**Re: U-Haul at 8200 Jefferson St. NE  
Erosion and Sediment Control Plan – C17E146 – (SWQ-2025-00051)  
Engineer’s Stamp Date: 1/13/26**

Based on the information in your submittal received on 1/13/26, the ESC Plan and Notice of Intent (NOI) cannot be approved until the following comments are addressed.

28816 ESC COVER

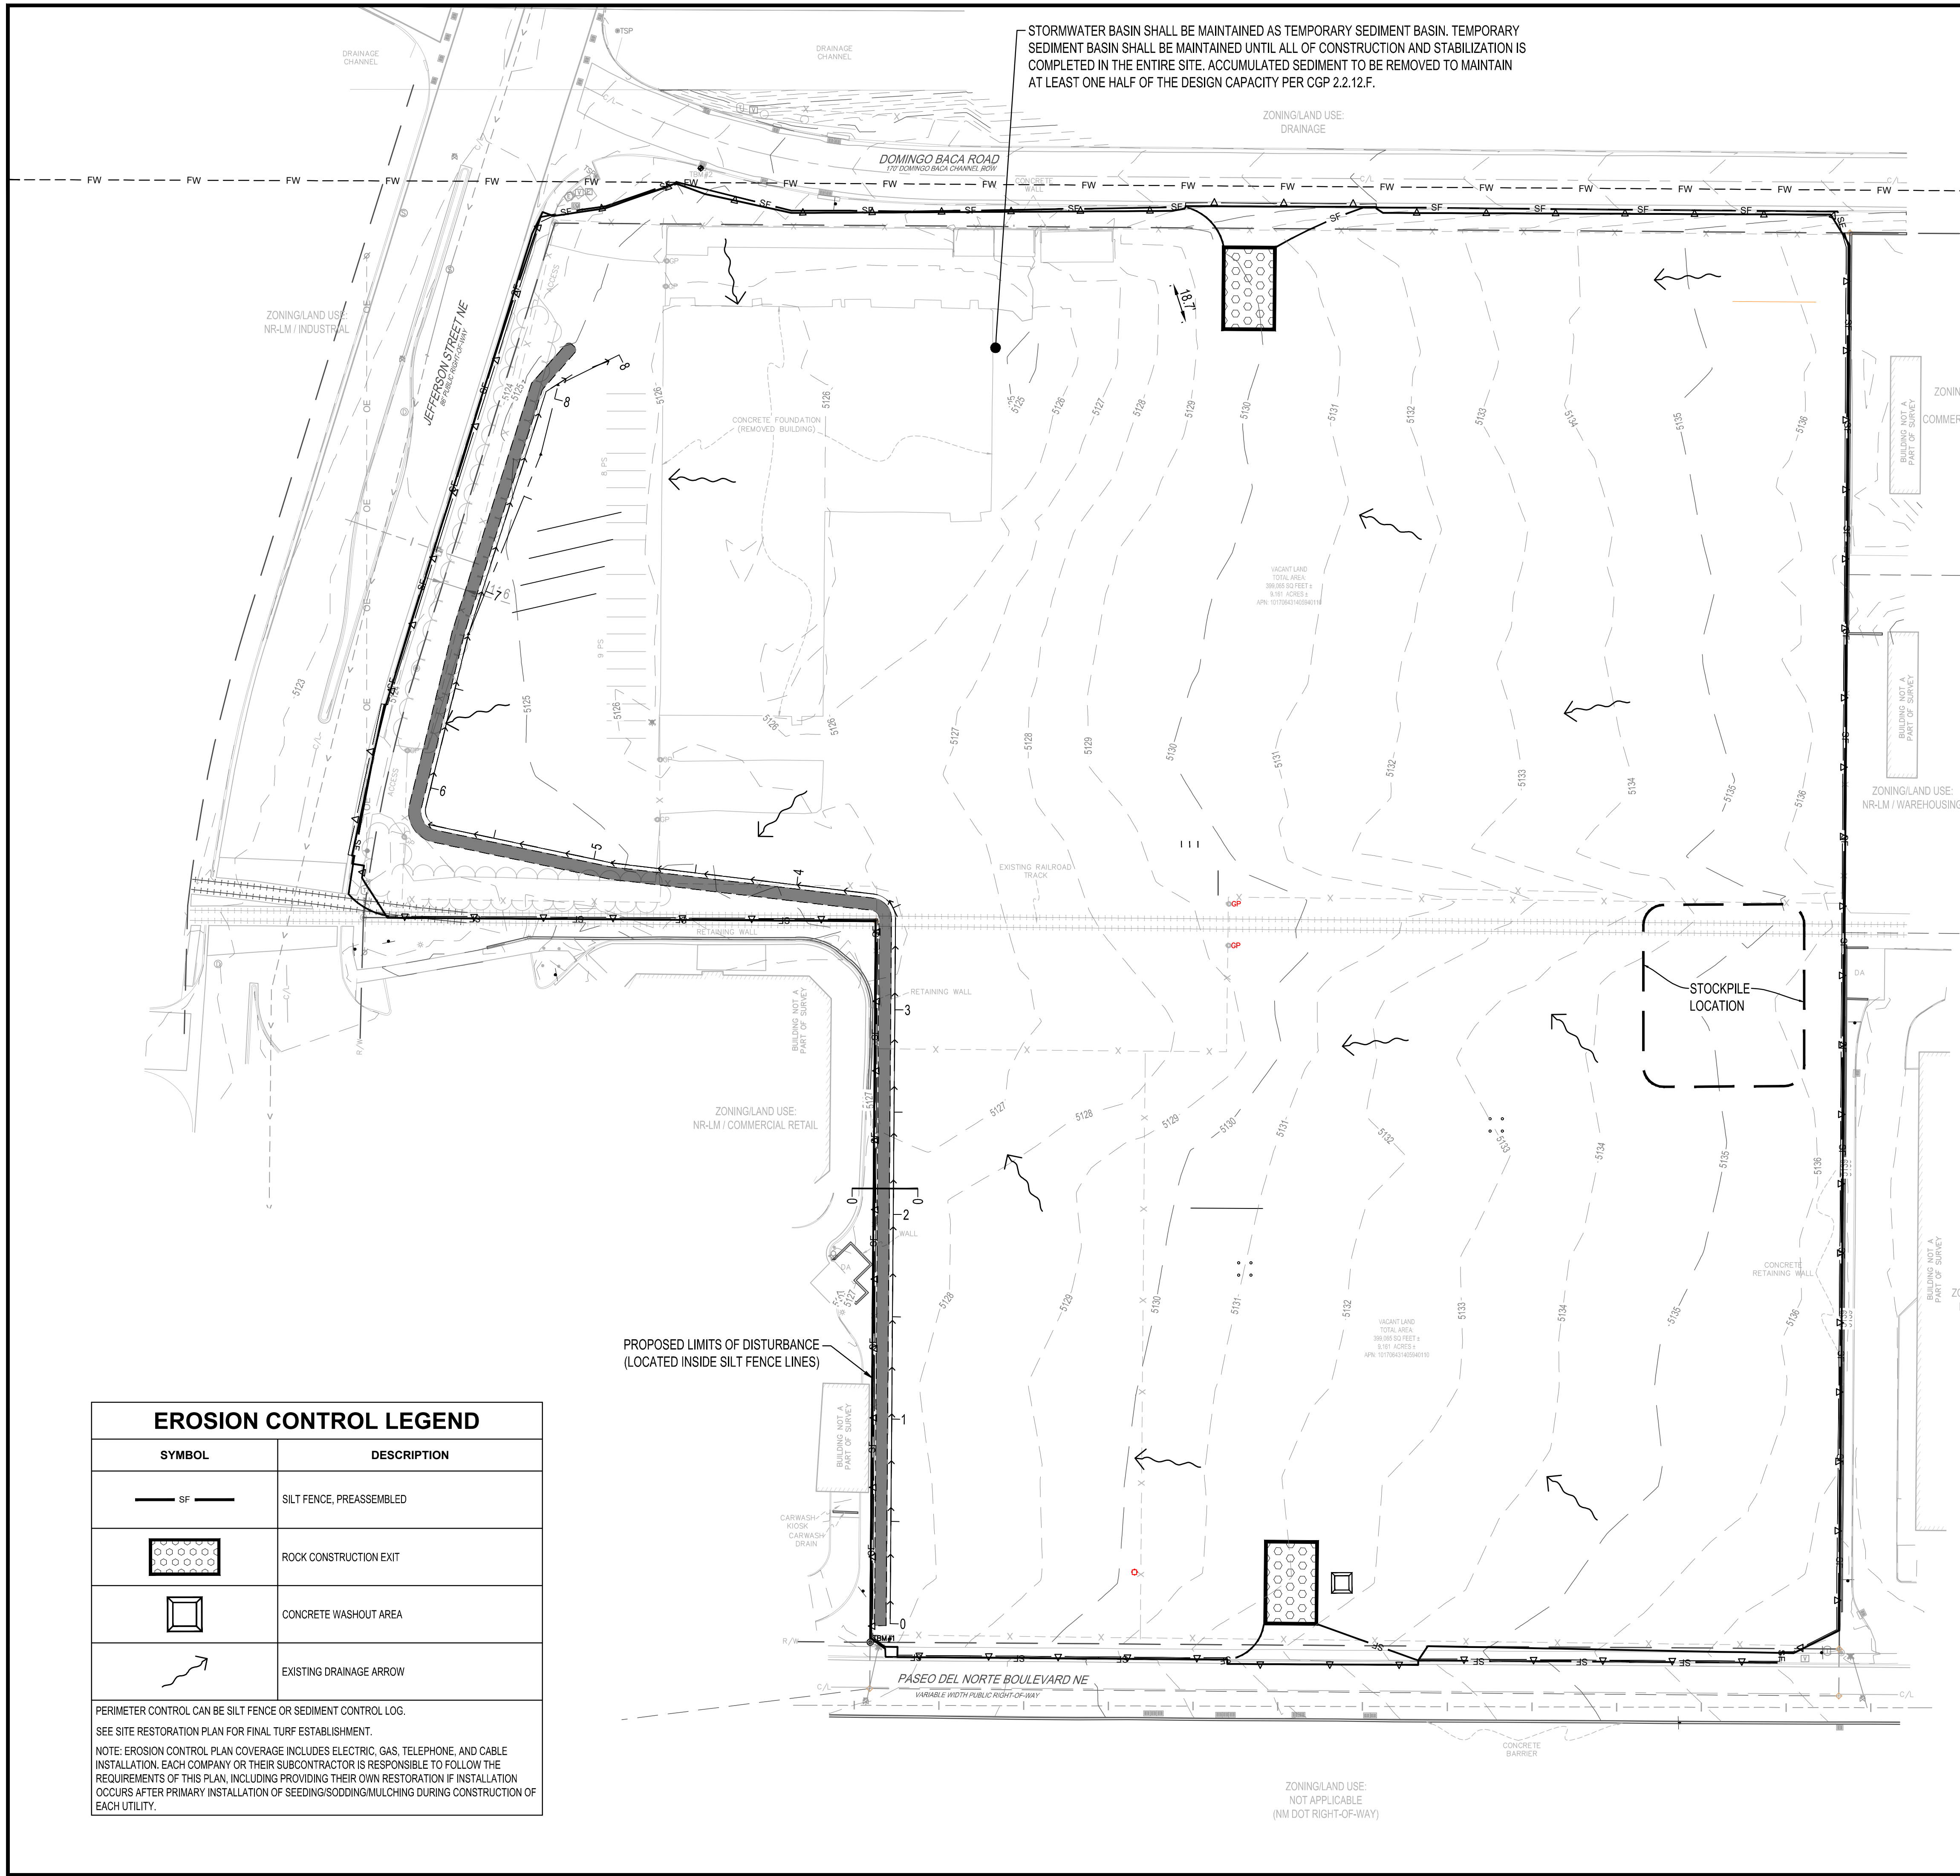
2. The sequence on the cover sheet should clearly state that the temporary northwest Sediment Basin (SB) and Diversion Channel (DC) are the first items of construction, before any land disturbance begins. Currently, it mentions site demolition, clearing and grubbing, and over-excavation of building pads before referring to the “cutting of the designed permanent retention pond.” The sequence also does not specify operating a temporary SB before or during construction. It must explicitly indicate that BMPs, including the temporary SB and DC, are installed first, prior to any land-disturbing activities, and differentiate between the temporary and post-construction versions of the pond. Additionally, it should state that these temporary controls require inspection and maintenance until construction is complete, stabilization is achieved, and the temporary BMPs are replaced by the post-construction SWQ ponds approved by hydrology.

2816 ESC 2

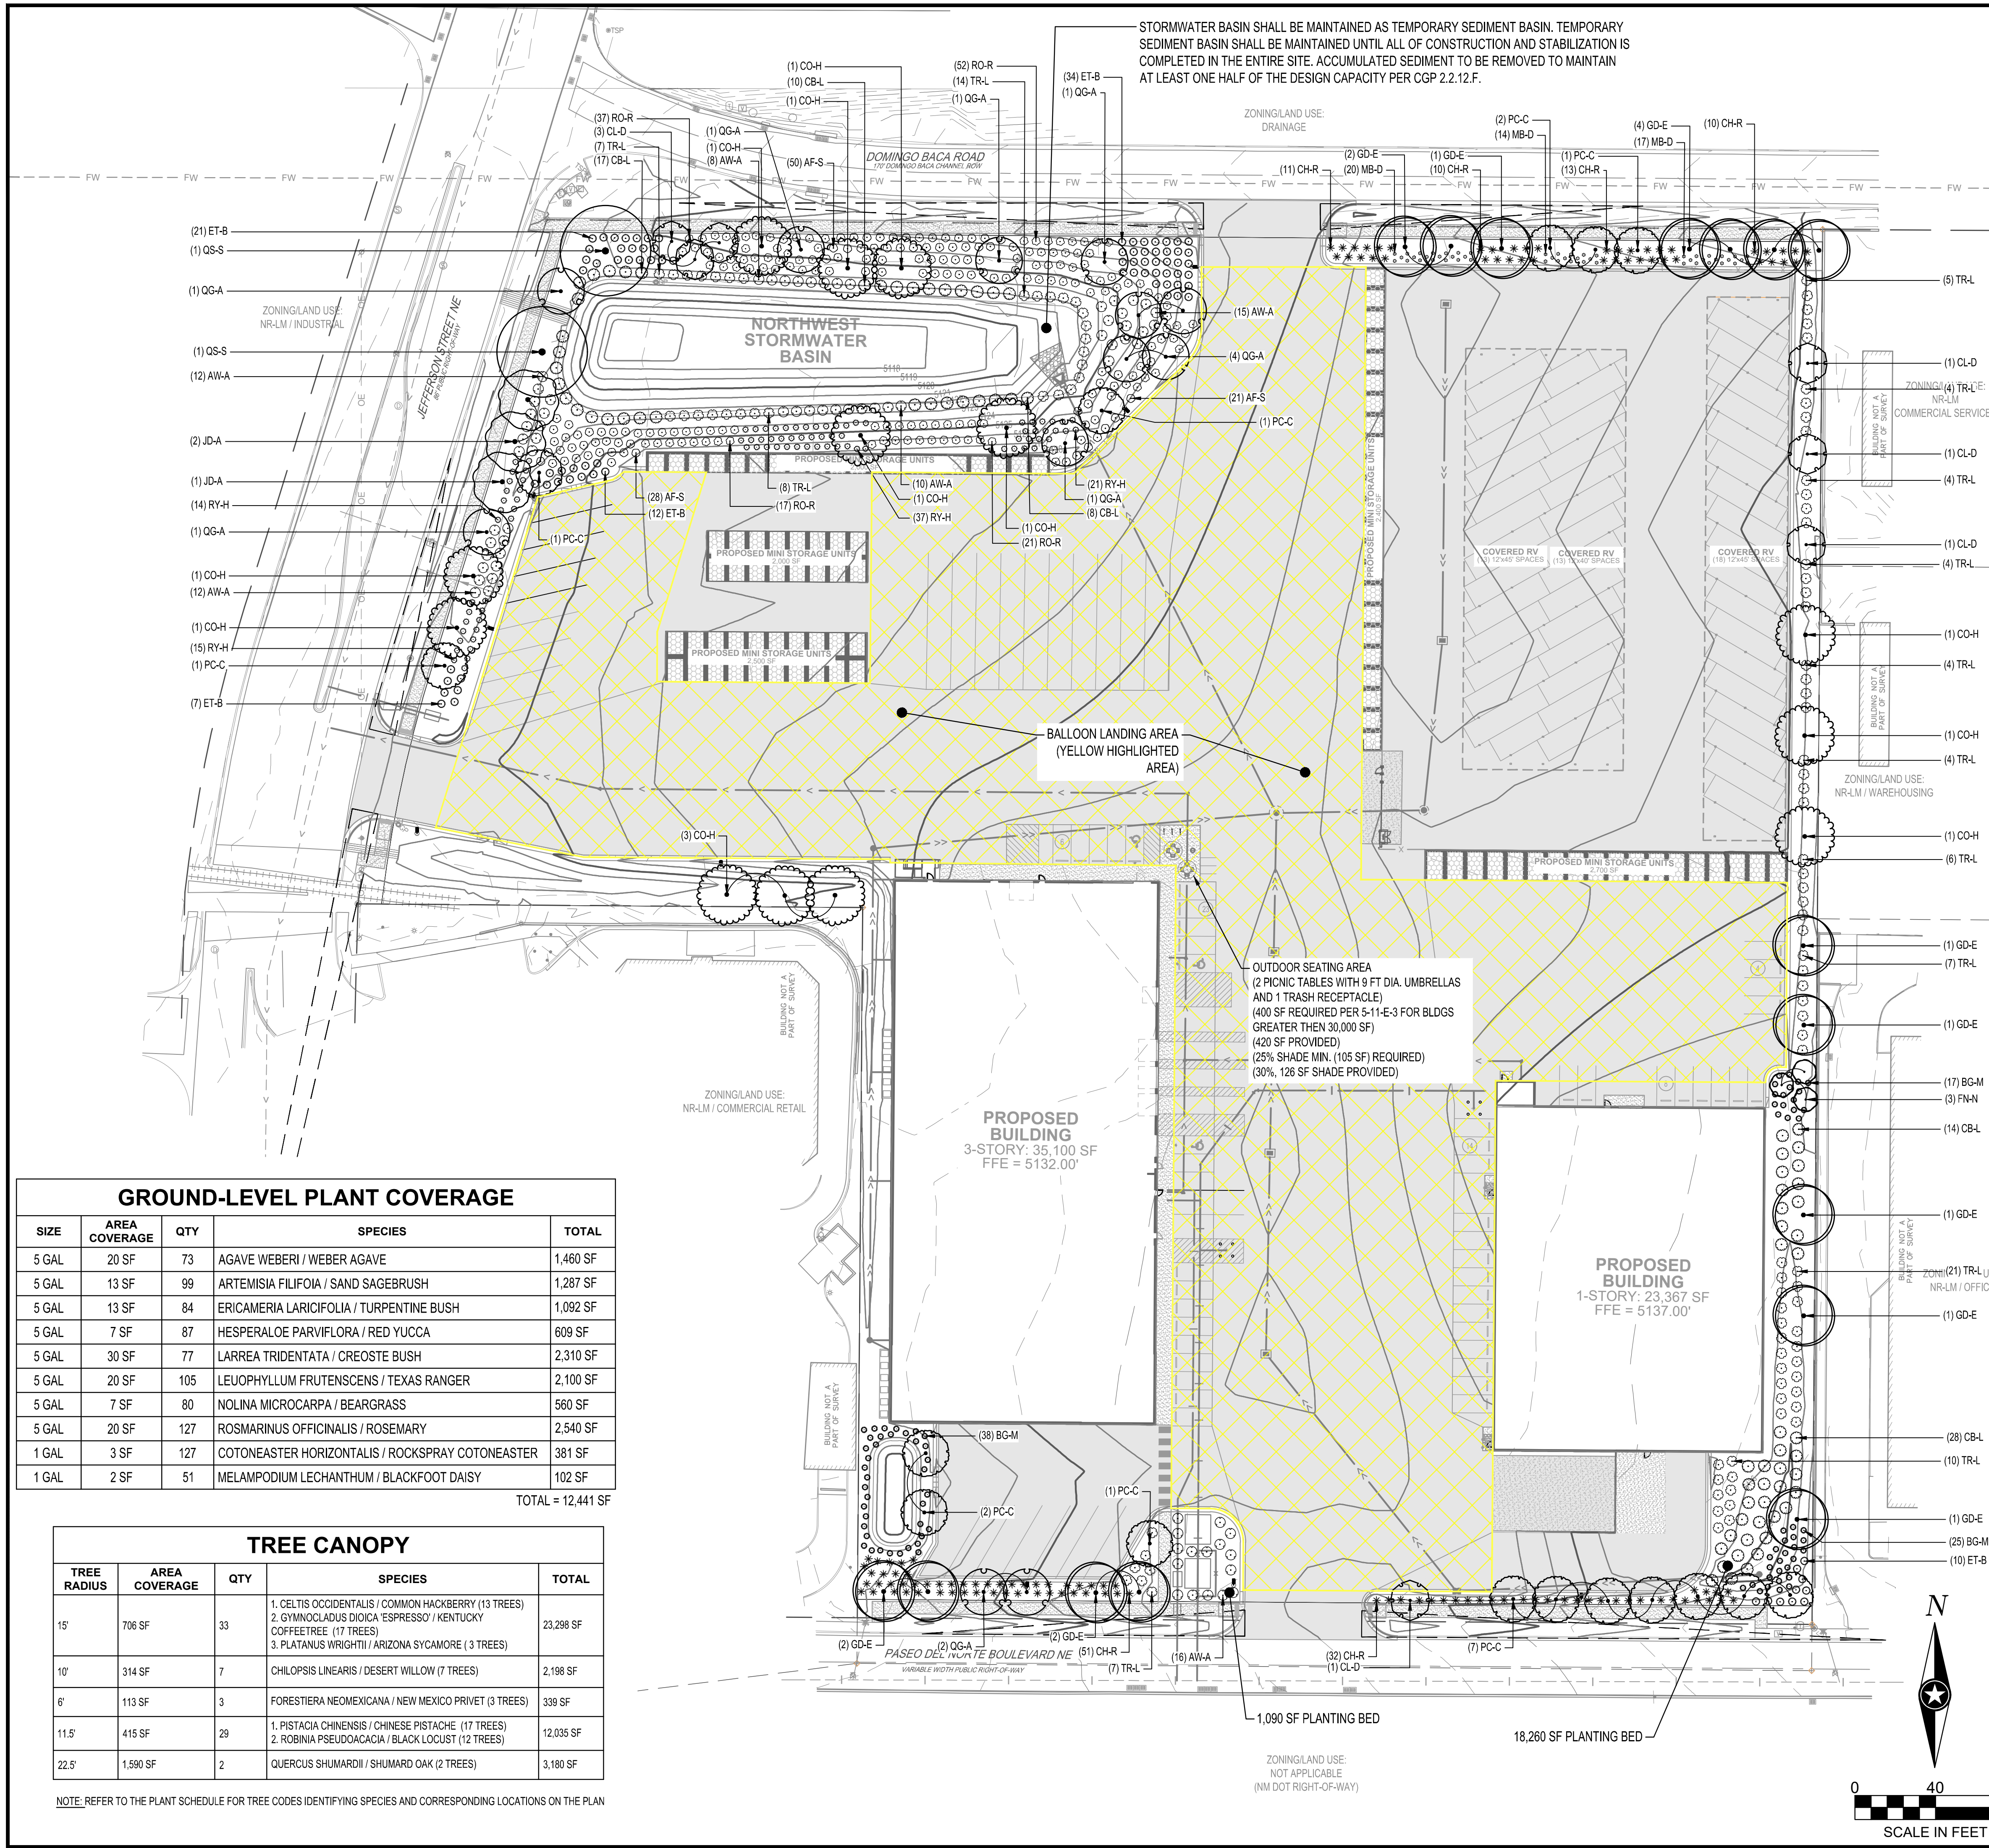
3. The note on sheet 3 about replacing the diversion channel with a storm drain west of the building appears poorly planned. Where are the inlets that intercept stormwater to replace the DC during construction? Provide locations and details of these inlets, along with the grading that will direct stormwater into the storm drain if this temporary stormwater control method is used. The storm drains should be added to the sequence and listed as one of the temporary controls on the cover page. They must be inspected and maintained, with sediment removed during construction. An alternative drainage structure on the property line west of the building should be considered instead of the temporary storm drain BMP.

5. Sheet 3 shows the same top elevation of the berm, 5128.14, at three consecutive locations west of the building, and the DC is less than 18 inches high at two of them. The lettering height of the elevations must be 0.1 inches or larger.
